Our Ref: M/37/20/NMA

Non-material amendment following grant of M/133/17/PL for removal of lantern light on rear conservatory and replace with 2 No. fixed skylights, finish external wall of conservatory in face brickwork and replace Cedral Lap system external wall cladding with Cedral click-plank system (no colour change)

Little Thatch, Caravan 93 Middleton Road Middleton-On-Sea PO22 6DW

SHEET 1

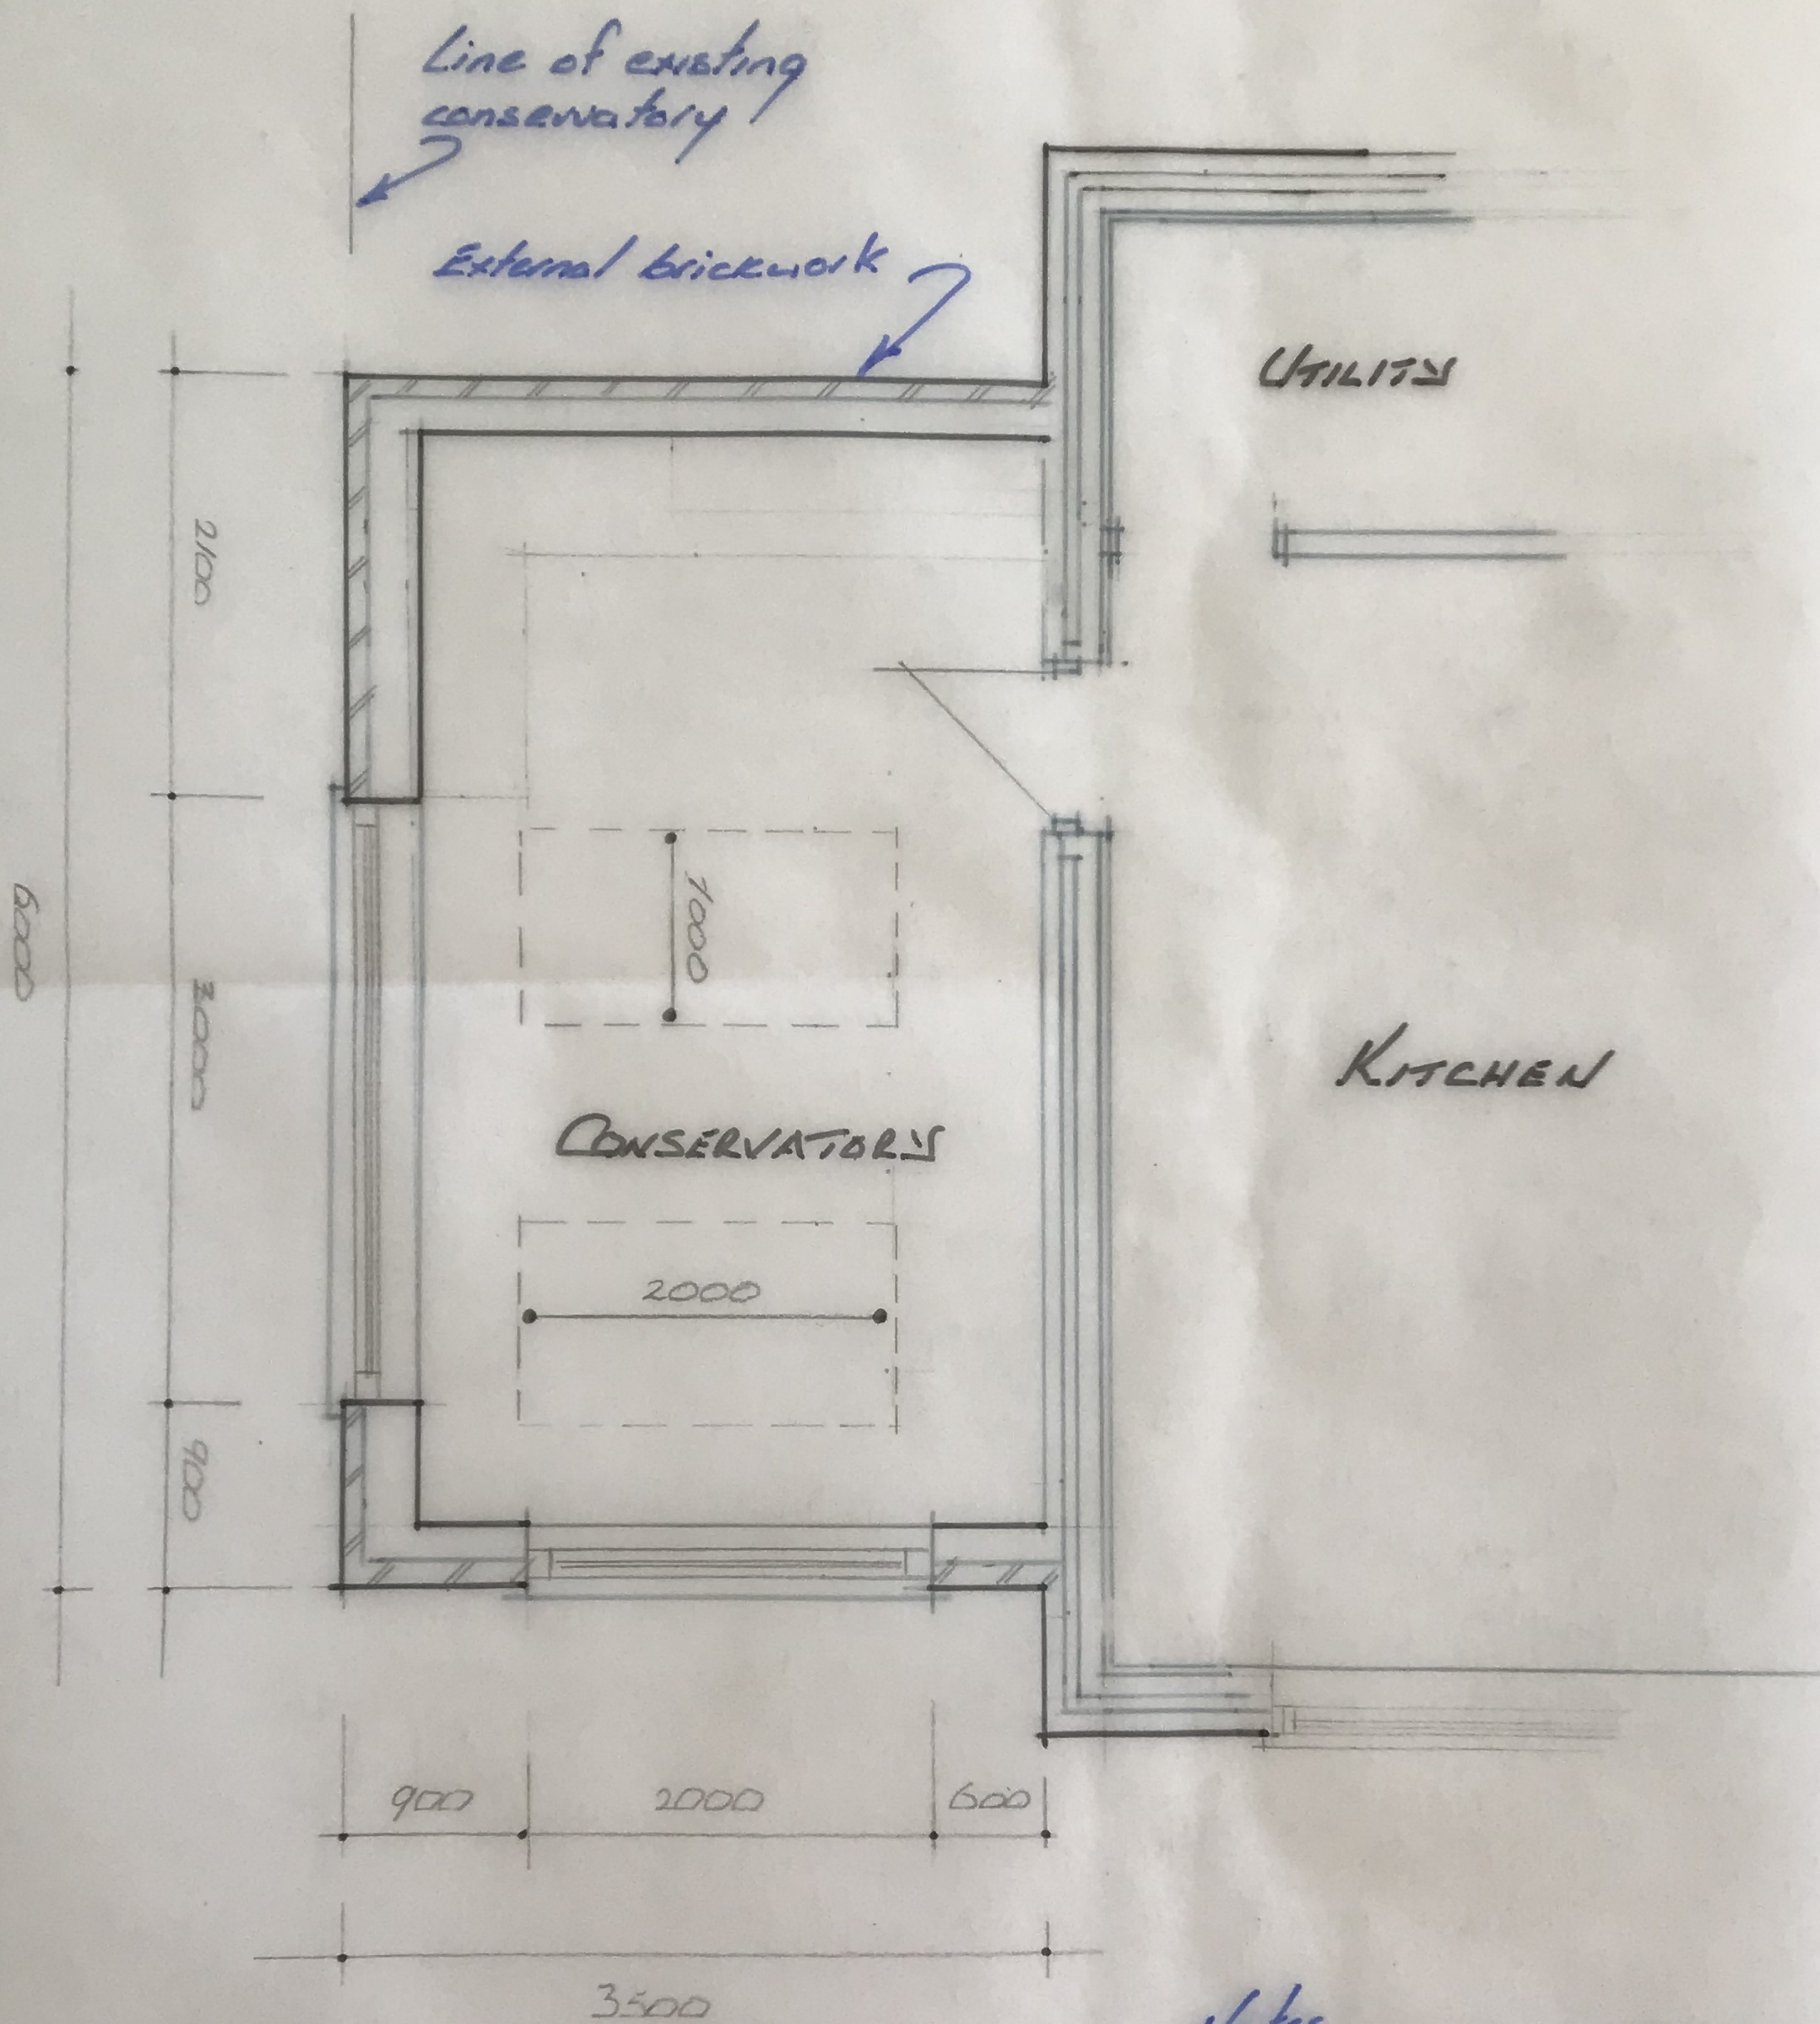
- Removal of the lantern light which was proposed to run East to West across the flat roof and its replacement with two low level fixed skylights running North to South within the roof construction;
- Construction of outer skin of the conservatory in facing brick.
- Change of cladding on the main house from approved Eternit Cedral Lap system to a Cedral Plank system. The cladding material and colour remain the same.
